Project/File: Trinity Grammar School

Application Number: SSD-10371-Mod-4

MODIFICATION APPLICATION TO MODIFY SSD 10371

MOD 4 – BASEMENT EXTENSION

Figure 8: Extract from modified Proposed Oval 3 Car Park B2.

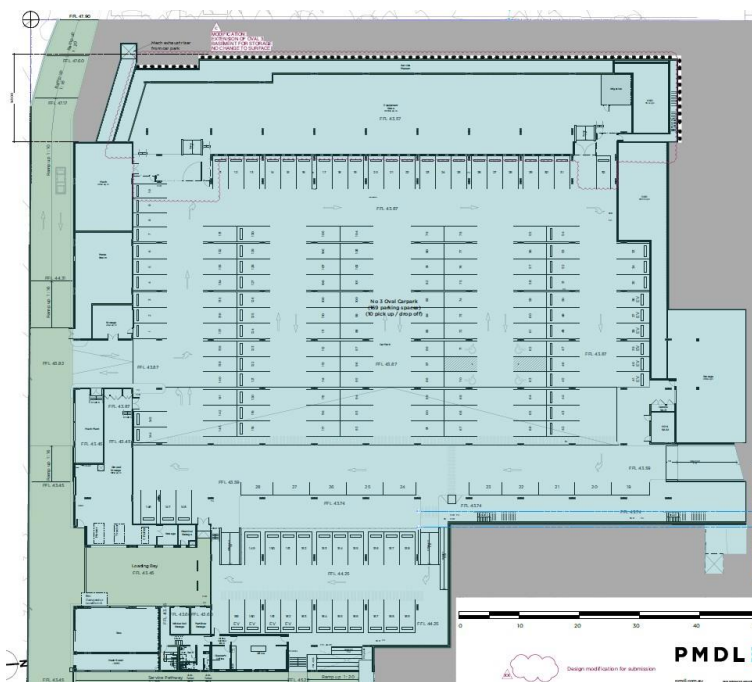
The Modification Report mentions an additional OSD tank being provided for the increased basement/ impervious area. The latest basement plan (2808-DA150) shows an additional OSD tank of 73.1m² to the north of the equipment storage. The Stormwater Management and WSUD contained in Appendix 23 of the approval SSD-10371 is required to be amended and verified by a qualified Hydraulic Engineer confirming that the new 73.1m² OSD tank will adequately attenuate additional flow from the extended basement storage to the pre-development or approved condition.

The approved Civil Engineering plan sheet SY180989_C3.50 shown on Appendix 24 - Civil Engineering Plans.pdf documents a basement area of 8,350 sq.m. while the latest basement plan 2808-DA150 shows 8,550 basement area equating to an increase of 200 sq.m. of basement extension.

The above-mentioned Civil Engineering plans sheet SY180989_C1.09 shows previously approved On-Site Detention (OSD) volume of 225 m³, while the latest Stantec's Civil documentation drawing CI-2-526-002 Rev 4 shows design for 272 m³ revised storage for OSD-3 in Oval 3 Basement 2.

Stantec confirms that the additional 47m³ OSD storage capacity on the revised tank shown on the latest documentation will be able to adequately attenuate flows from the additional 200m² basement extension to the previously approved condition.
